SUBMISSION TO NSW PLANNING AND ENVIRONMENT CROWN SYDNEY HOTEL RESORT

SSD 15_6957 Crown Sydney Hotel Resort Environmental Impact Statement

This submission is the Museum's formal response to the development application submitted to the department by **Crown Sydney Hotel Resort** referred to as **SSD 15_6957 Crown Sydney Hotel Resort Environmental Impact Statement**. It specifically responds to the impact assessment that relates to the Sky View Impact Assessment, which forms part of the EIS.

02 EAST ELEVATION
ELEVATION - SCALE 1:300 @ A0

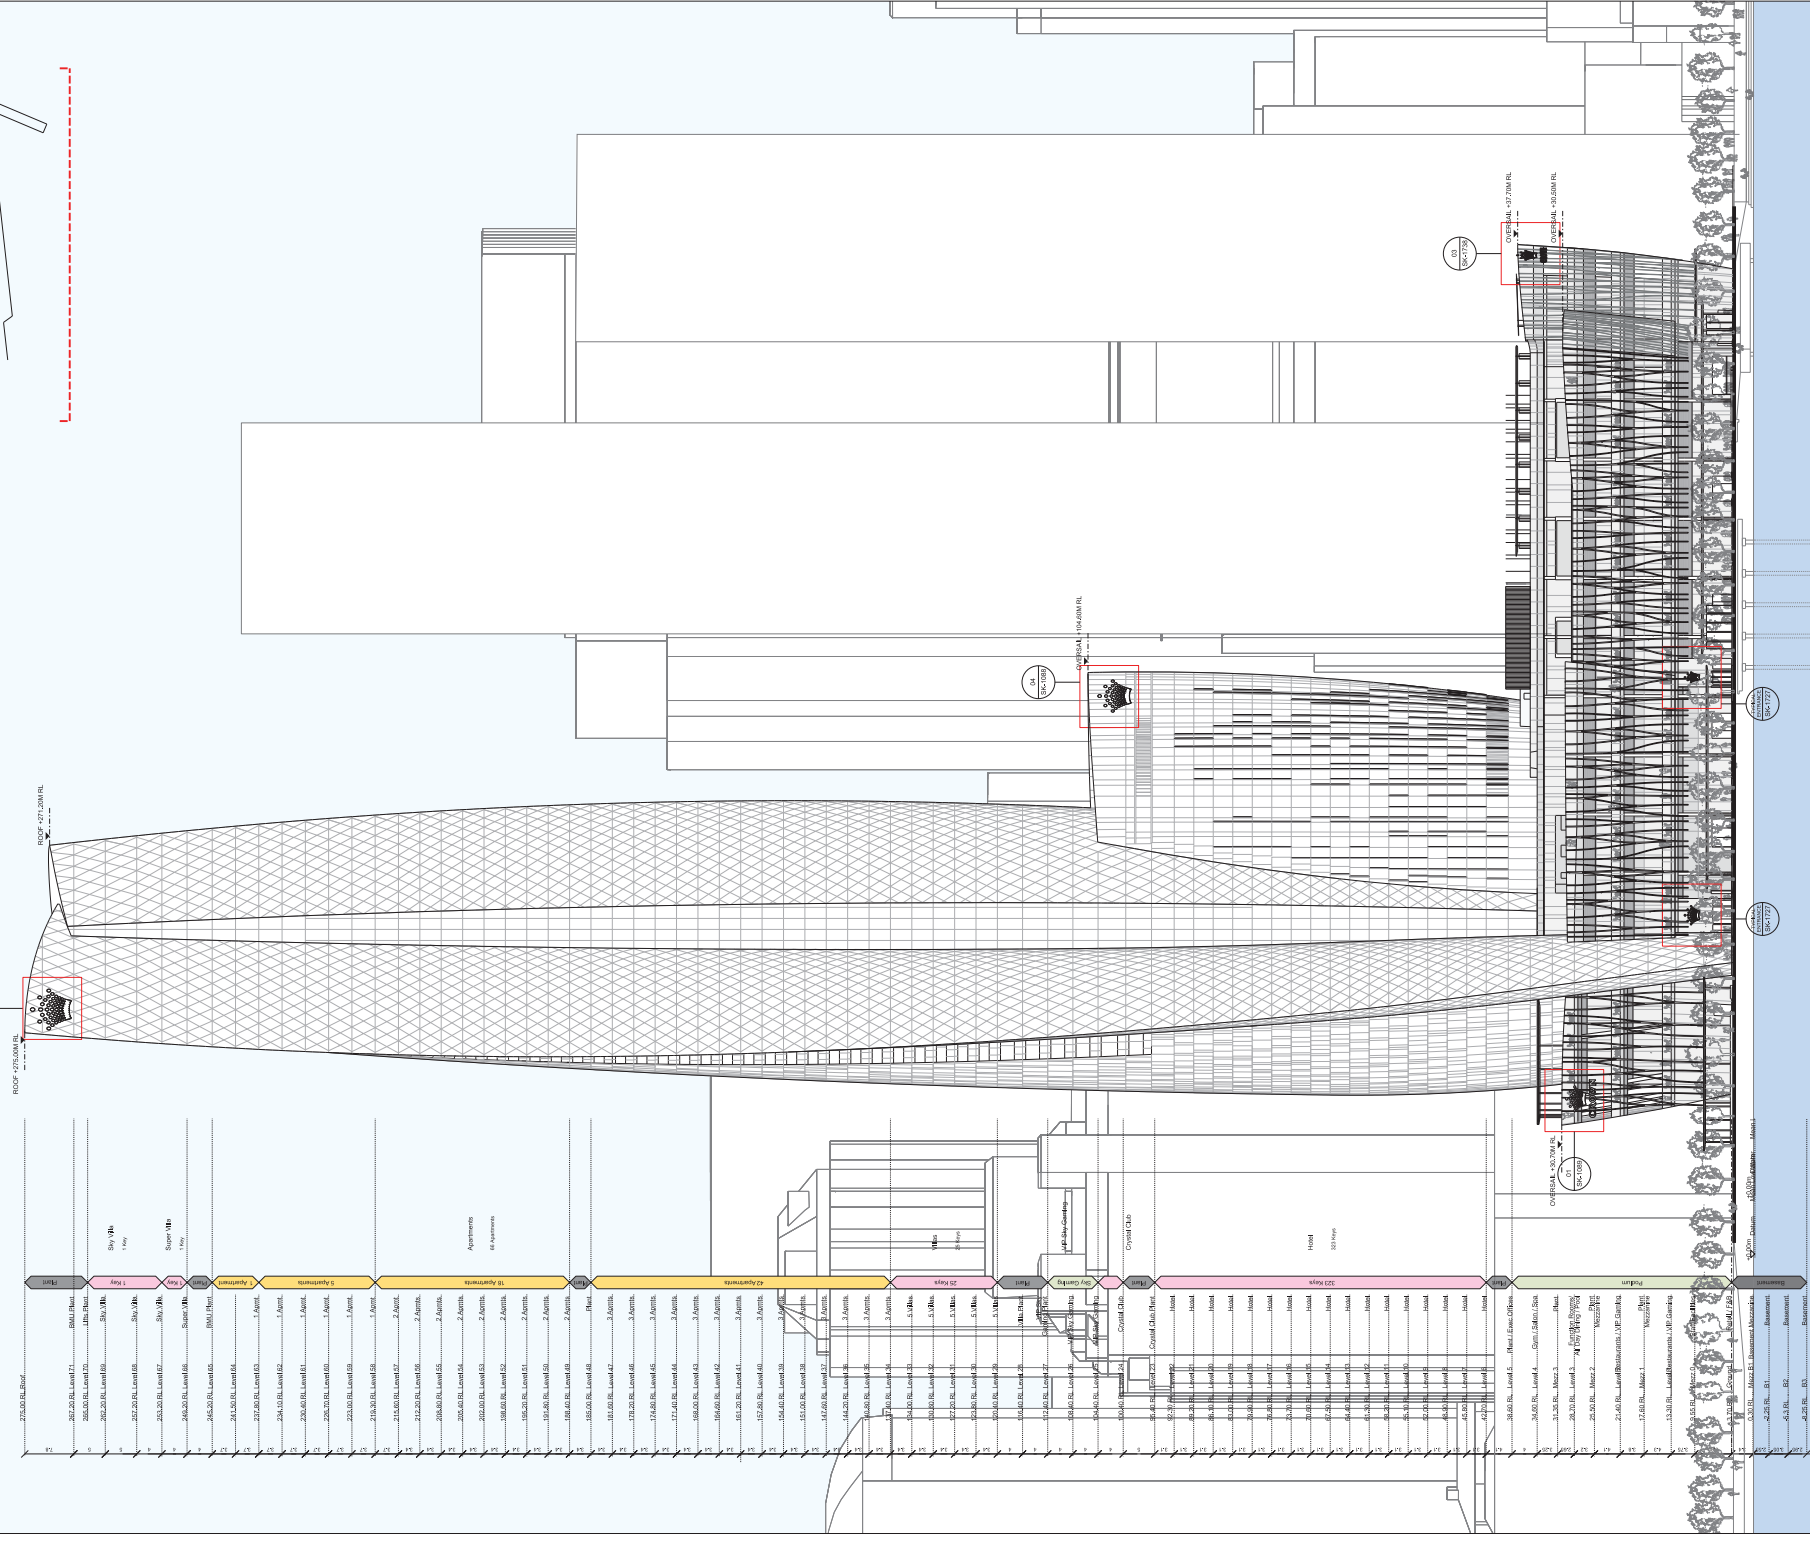
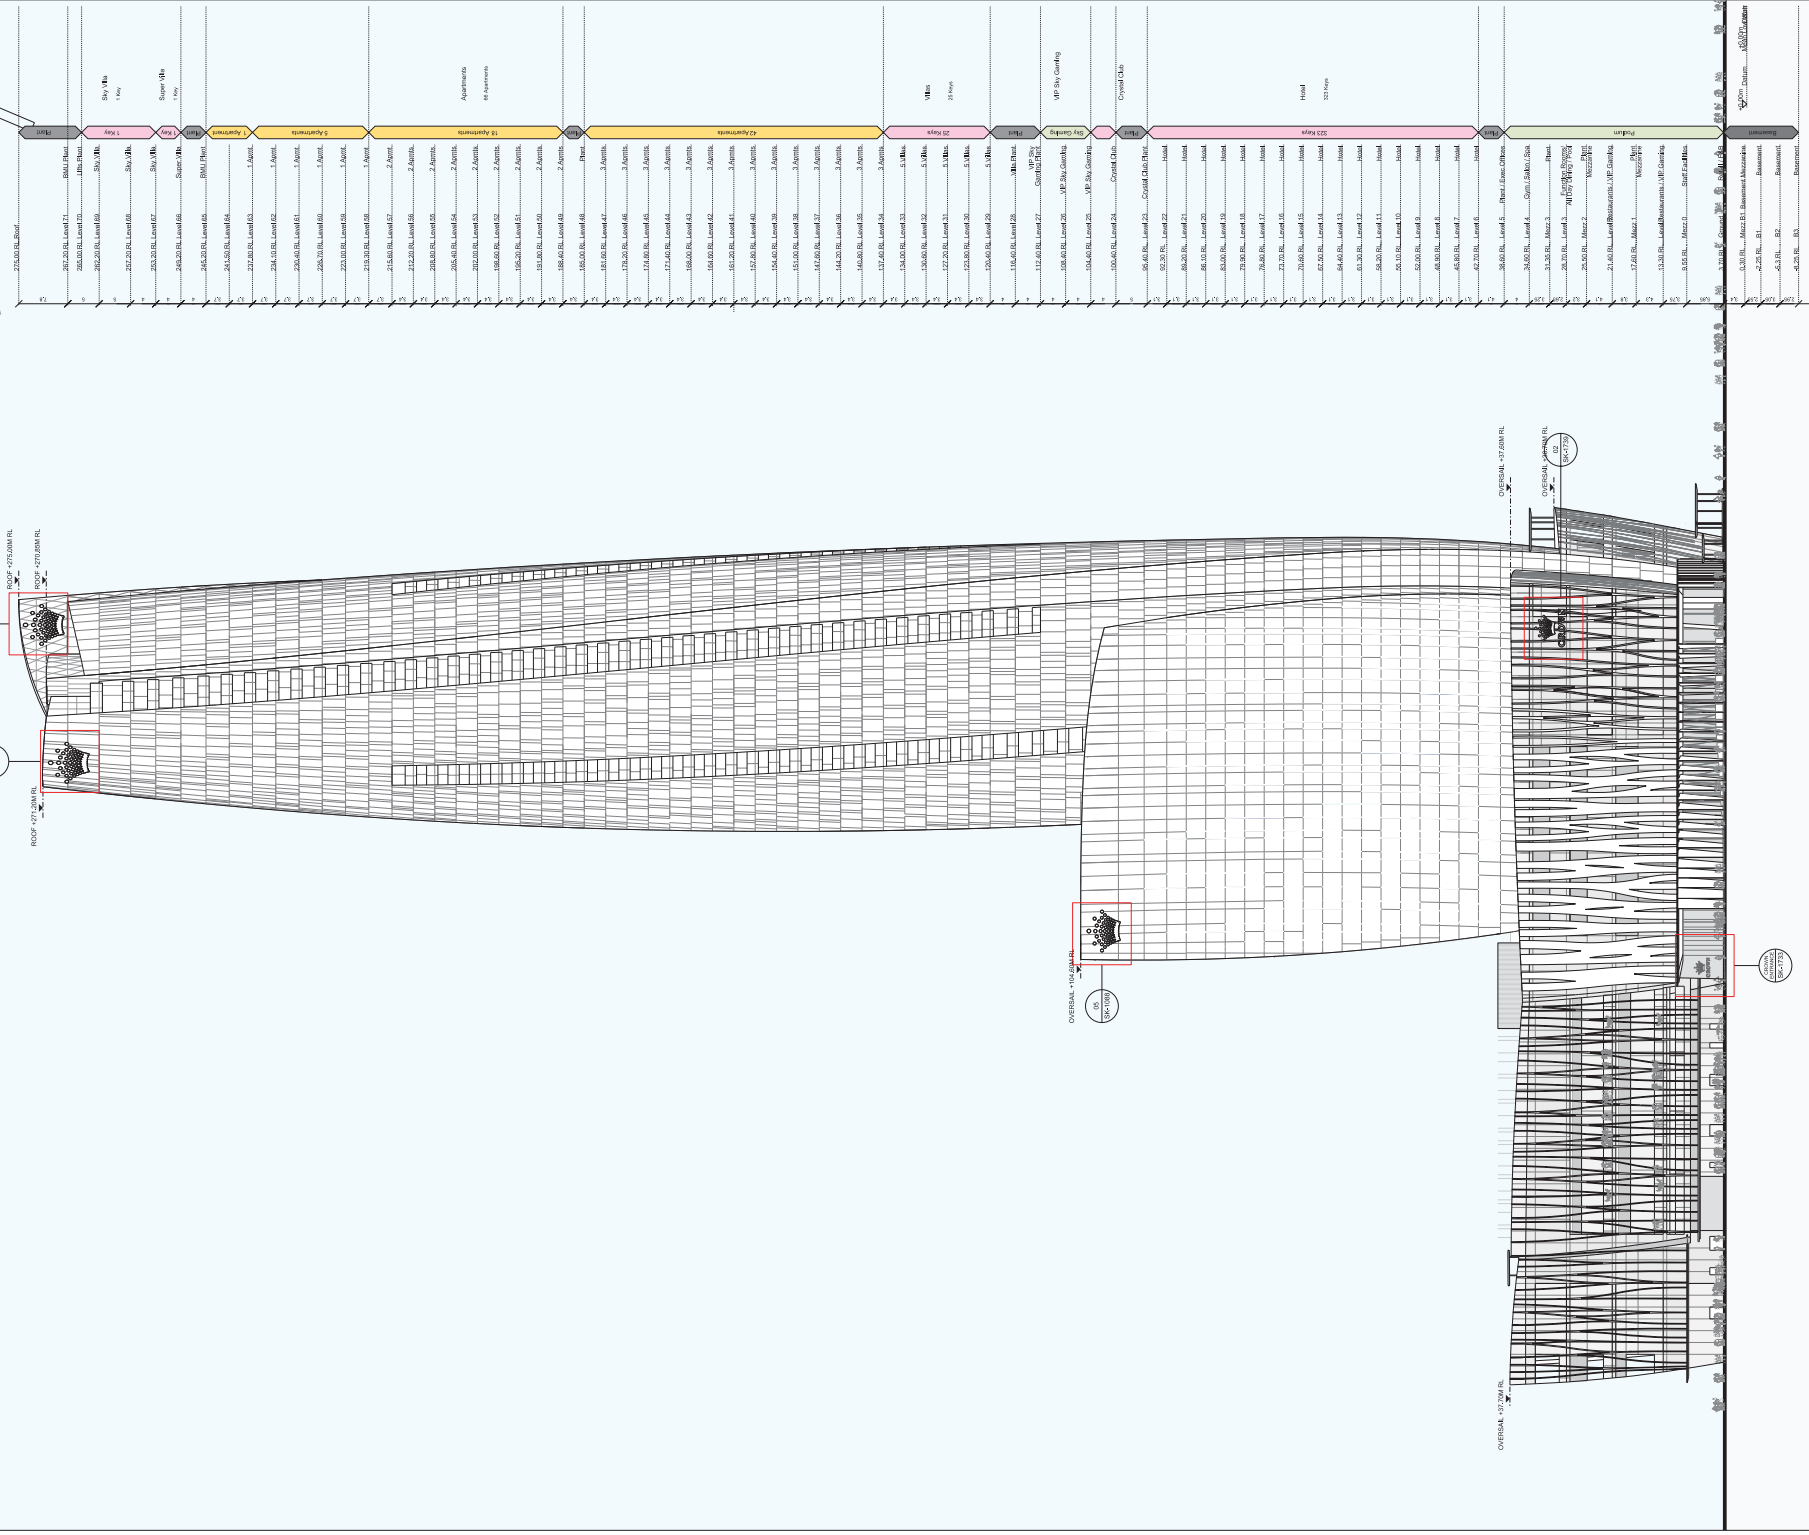
CSHR will spill light to the sky reducing the contrast between the background sky and objects viewed from Sydney Observatory making objects more difficult to view. The EIS does not reference the impact of light spill on Sydney Observatory from the eastern facades of CSHR which will likely feature extensive use of glass, to maximise views to the city and Sydney Harbour. More details in relation to lighting of this façade is requested and a commitment at this stage that light spill will be minimised.

MAAS recommends the effect of light spill can be minimised by shielding lighting, eliminating up-lighting, not using blue lighting, the use of sensor & timed lighting.
